**PREAPPLICATION MEETING NOTES**

**Subject:** Melvin R. Sampson Coho Hatchery  
**Re:** Preapplication Conference Application

PM-16-00015

To:	Internal	Project:	MRS Coho Facility - EPC
From:	Kevin Jensen	cc:	File
Date:	April 13, 2017	Contract No.:	00071156
Subject:	Melvin R Sampson Coho Facility EPC – Kittitas County Permitting – Fire, Septic and Water

**Figure 2**

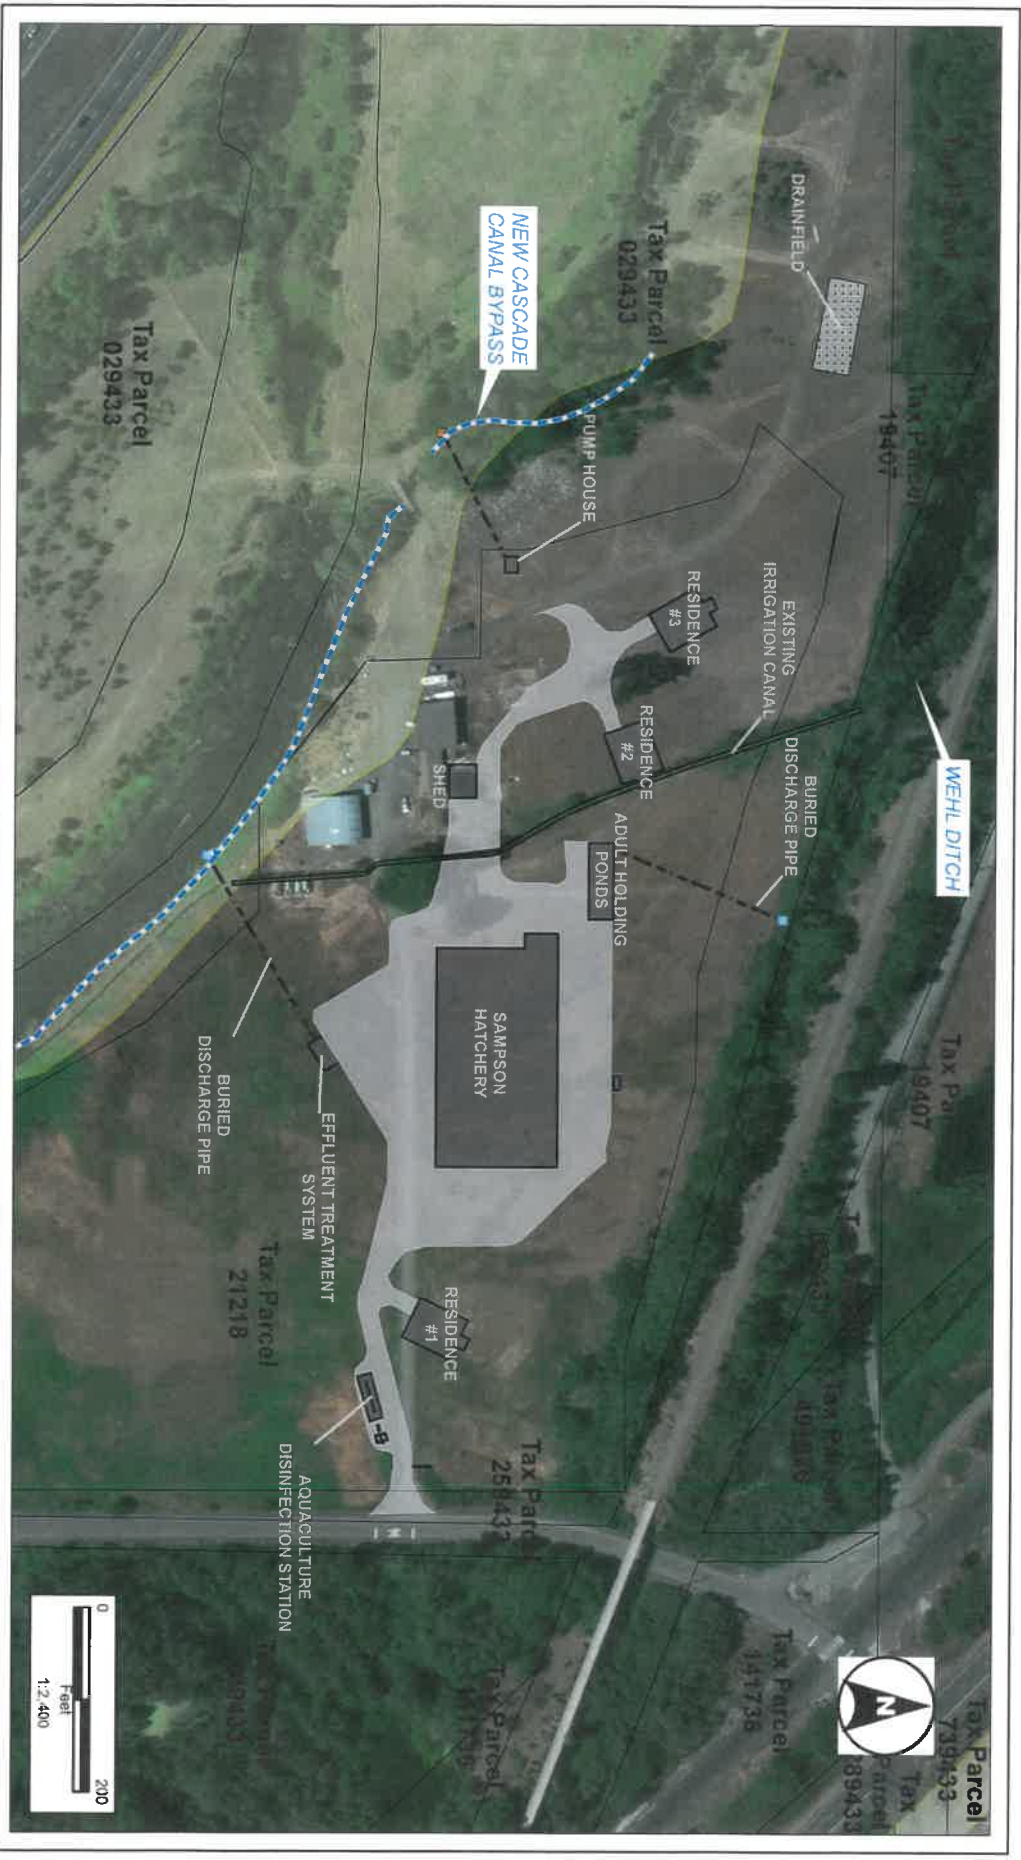
1. There must be a 100-foot setback from all “structures”. We discussed this at length. Essentially there are three options:
  - i. Decommission the existing well and drill a new potable water well with the appropriate setbacks. From a permitting perspective, this new really be no different than the process we have to go through anyway. It would, however, cost more to drill a new well and to decommission the existing one.

- ii. Re-design the layout of the facility so that the hatchery building (and holding ponds? Unclear) are 100 feet away from the potable water well.
  - iii. Request a variance through the state. Holly is pursuing this with Russell Mau, who works for the state. I requested that she bring up a few things in her conversation with him, including:
